**From:** Nolan, Chris <Chris.Nolan@lancashire.gov.uk>  
**Sent:** 25 July 2017 14:34  
**To:** Victoria Walmsley; planning  
**Cc:** LHS Customer Service  
**Subject:** D3.2017.0557 - 2 Warwick Drive Clitheroe

Planning Application No: 3/2017/0557  
Grid Ref: 374774 442577  
Proposal: Two storey extension to the side.  
Location: 2 Warwick Drive Clitheroe BB7 2BG

Roof/Site Plan

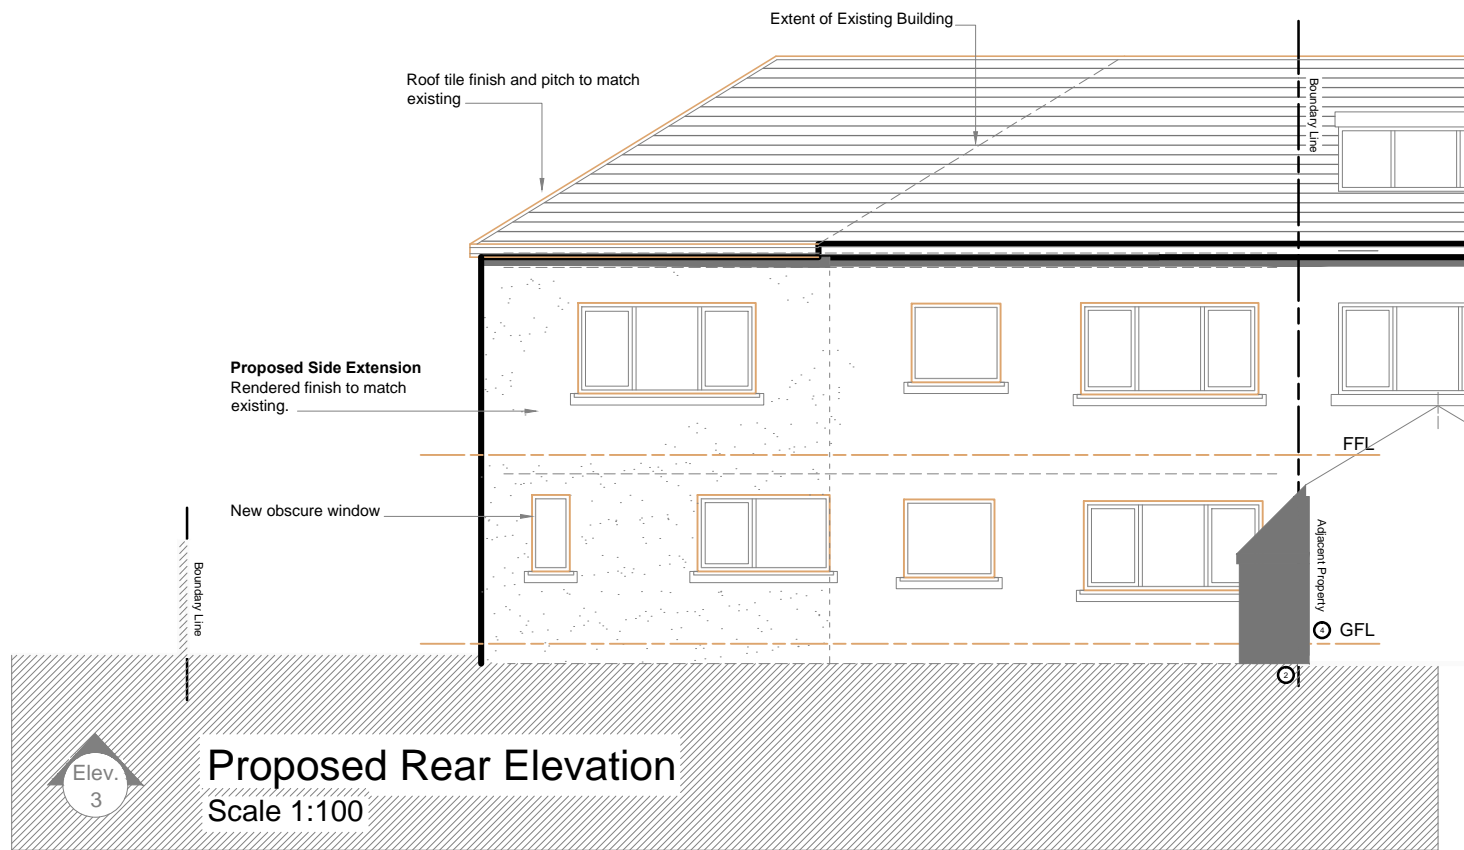
With regard to the above planning application for a two storey side extension. The extension will increase the number of bedrooms within the house from three to four and for that reason we would be looking to see off road parking for three vehicles. This has been indicated on the plan and for that reason I would not raise any objections on highway grounds. However to create the spaces the present vehicular crossing will need to be extended and this work will need to be completed by Lancashire County Council or one of their agents. For this reason I would ask for the following Conditions notes to be added to any permissions your council is minded to grant.

1. No part of the extension hereby approved shall be occupied until the additional parking provision has been constructed and completed in accordance with the scheme details. In order the parking standards for the size of dwelling are met.
